**KIRKLEES METROPOLITAN COUNCIL
INVESTMENT & REGENERATION SERVICE**

DELEGATED DECISION TO DETERMINE PLANNING APPLICATIONS

Reference No:	2025/62/90023/W
Site Address:	18, Meltham Road, Honley, Holmfirth, HD9 6HX
Description:	Change of use from domestic garage to dog grooming unit
Recommending Officer:	Joanna Rednall

DECISION – Conditional Full Permission

TITLE: CHANGE OF USE FROM GARAGE TO DOG GROOMING  
SITE ARRANGEMENT & LOCATION PLAN

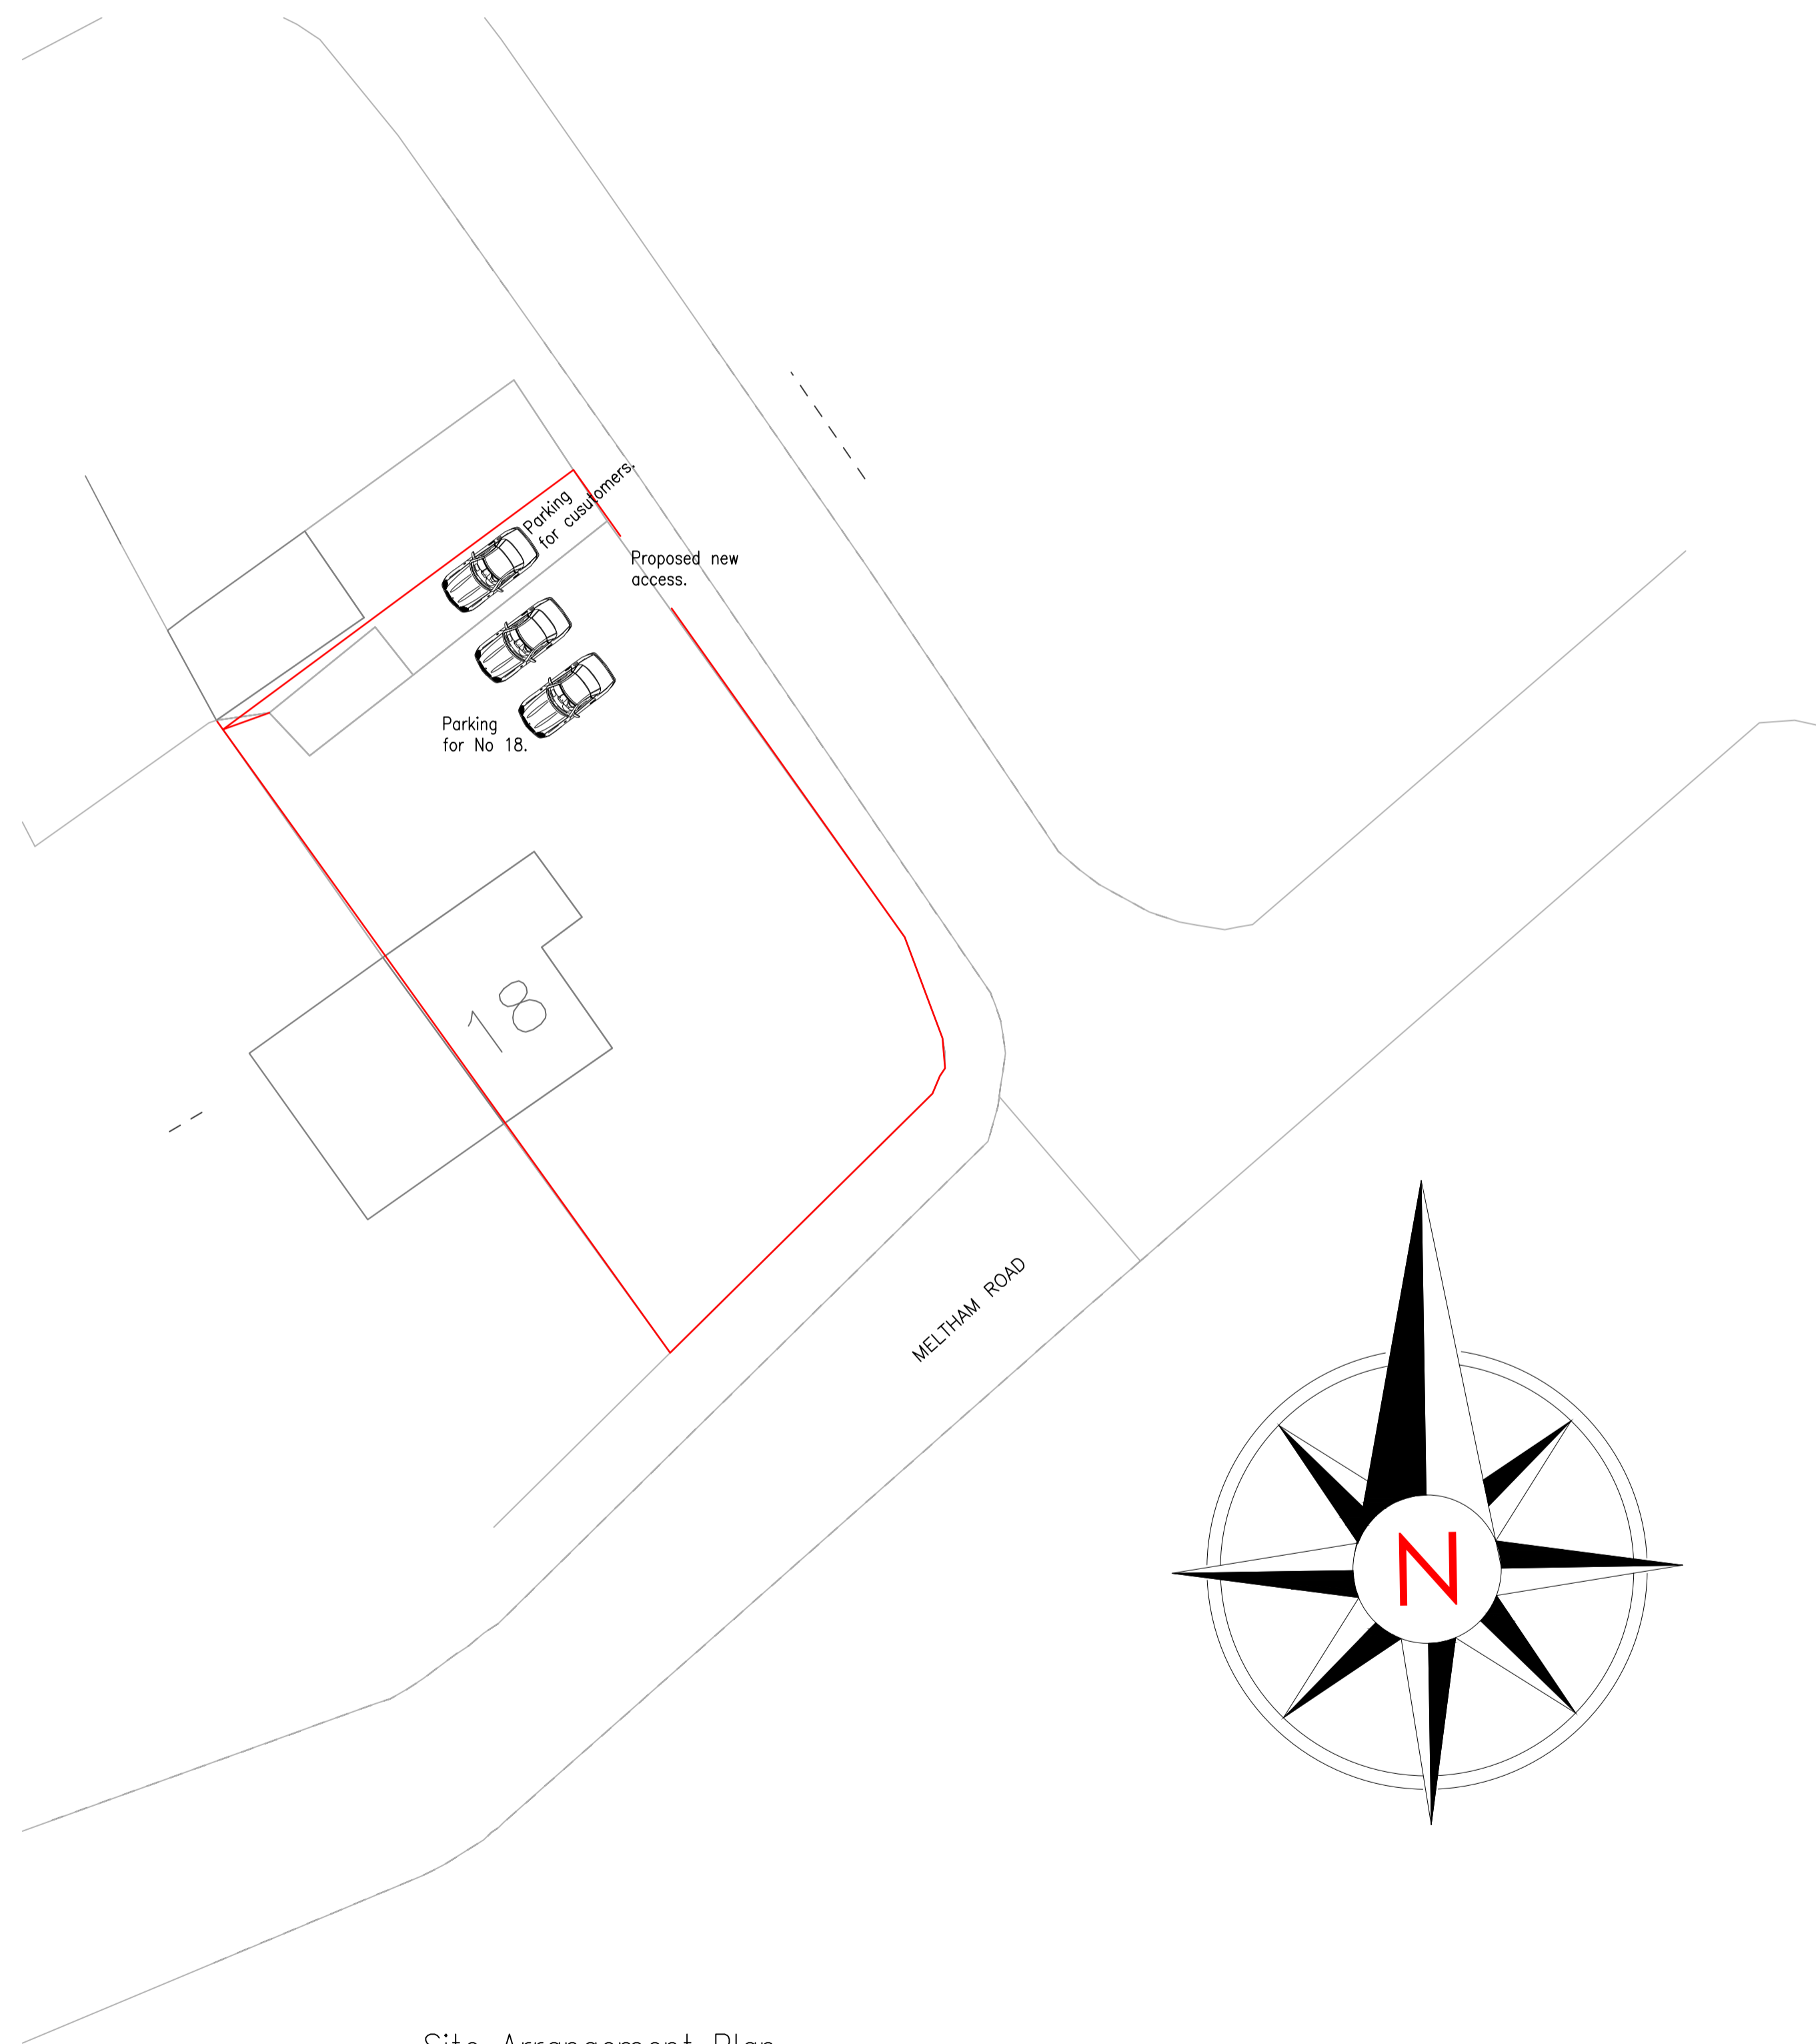
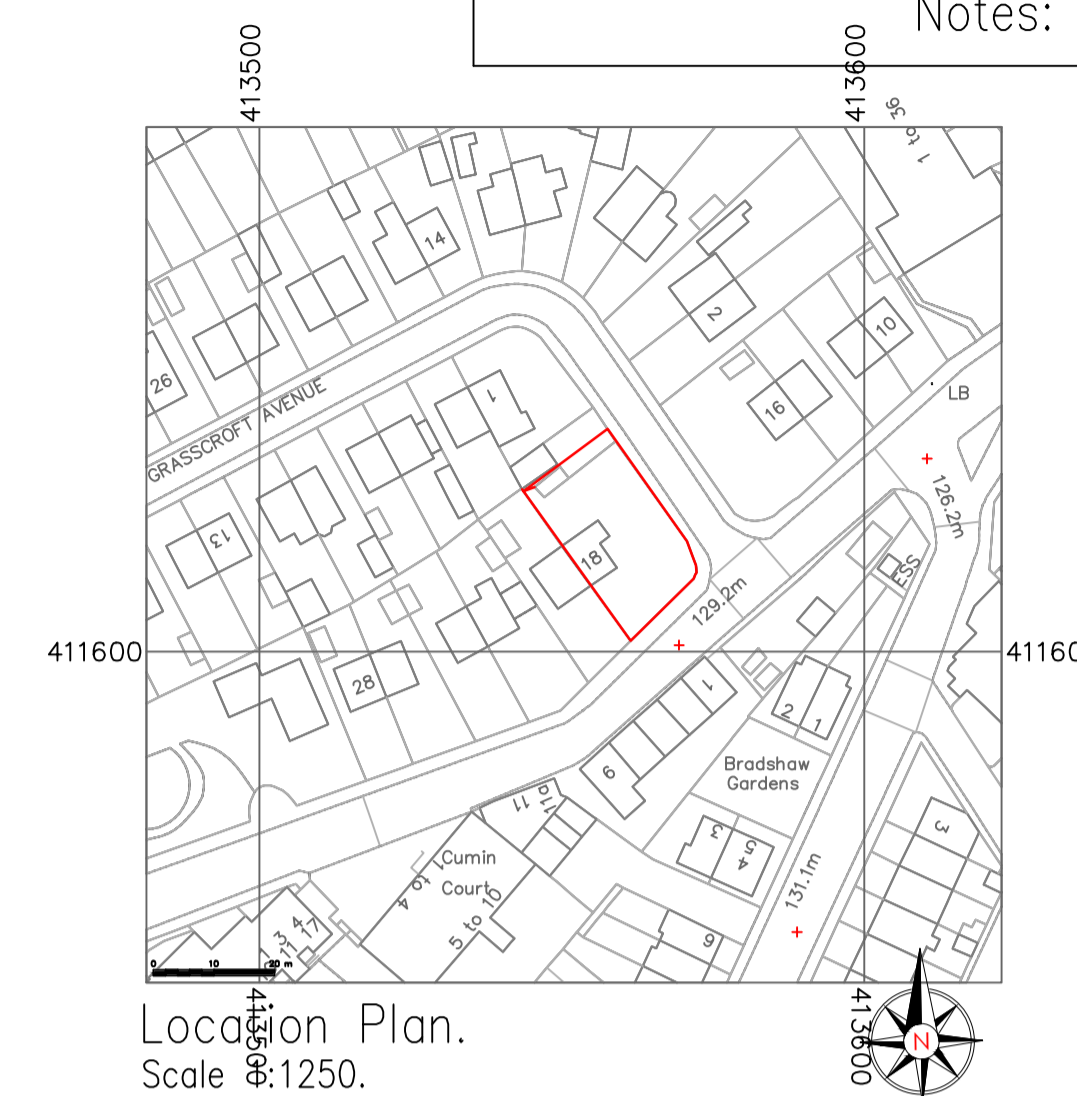
The proposal involves a change of use from a domestic garage to a dog grooming unit. The visual alterations are modest and include the removal of the existing garage door from the front elevation, replaced by a door and a window. A new window is also proposed for the rear elevation. The garage is

set approximately 10 metres back from the pavement and the siting or size of the garage would not be altered as part of the development. Officers consider these minor alterations would have an acceptable visual impact on the street scene and given its set-back position from the highway, it is considered the proposed alterations would not appear incongruous or out of character with the street.

Additionally, officers have noted that the size of the garage will remain unchanged, meaning there will be no undue overbearing or overshadowing impact on the neighbouring properties. New windows are proposed for both the front and rear elevations, with the rear window introducing an opening where none currently exist. While this could potentially lead to overlooking of No. 20, Meltham Road, it is important to note that the garage will not be a habitable structure. Furthermore, the orientation of the garage in relation to neighbouring dwellings ensures that the windows will not directly face habitable windows. Officers also observed that there is adequate boundary treatment along the common boundary, which will help to prevent any significant loss of privacy at No. 20, Meltham Road.

As part of the determination of this application, an informal consultation was undertaken with KC Highways Development Management. The Highways Team note the existing property benefits from one off-street parking space to the front of the garage which accessed off Grasscroft Avenue. The proposed site plan shows off-street parking spaces for 3 vehicles as well as a new access adjacent to the existing. Officers consider the proposed change of use from garage to dog grooming unit would not have a harmful impact upon parking and would not significantly intensify the use of the dwelling. It is considered the additional trips to the site in relation to the dog grooming unit will not be significant as there would be off-street parking provided on site, as well as unrestricted parking to the front of the site. For the scale of development, this parking provision is considered to be acceptable. A condition will be imposed restricting the number of employees to that of the resident of the property.

2. Before the development is brought into use, a Noise Mitigation Scheme shall be submitted to and approved in writing by the Local Planning Authority. The scheme shall include details of any reasonable steps to mitigate noise. The approved scheme shall be implemented before the development is brought into use and retained thereafter.

3. All doors and other openings shall be kept closed except in cases of emergency

4. The use hereby permitted shall not be open to customers outside the hours of:

0800hrs to 1800hrs Monday to Friday, and
0800hrs to 1400hrs Saturday

5. The dog grooming unit hereby approved shall only be operated by a permanent resident of 18 Meltham Road, Honley, Holmfirth HD9 6HX.
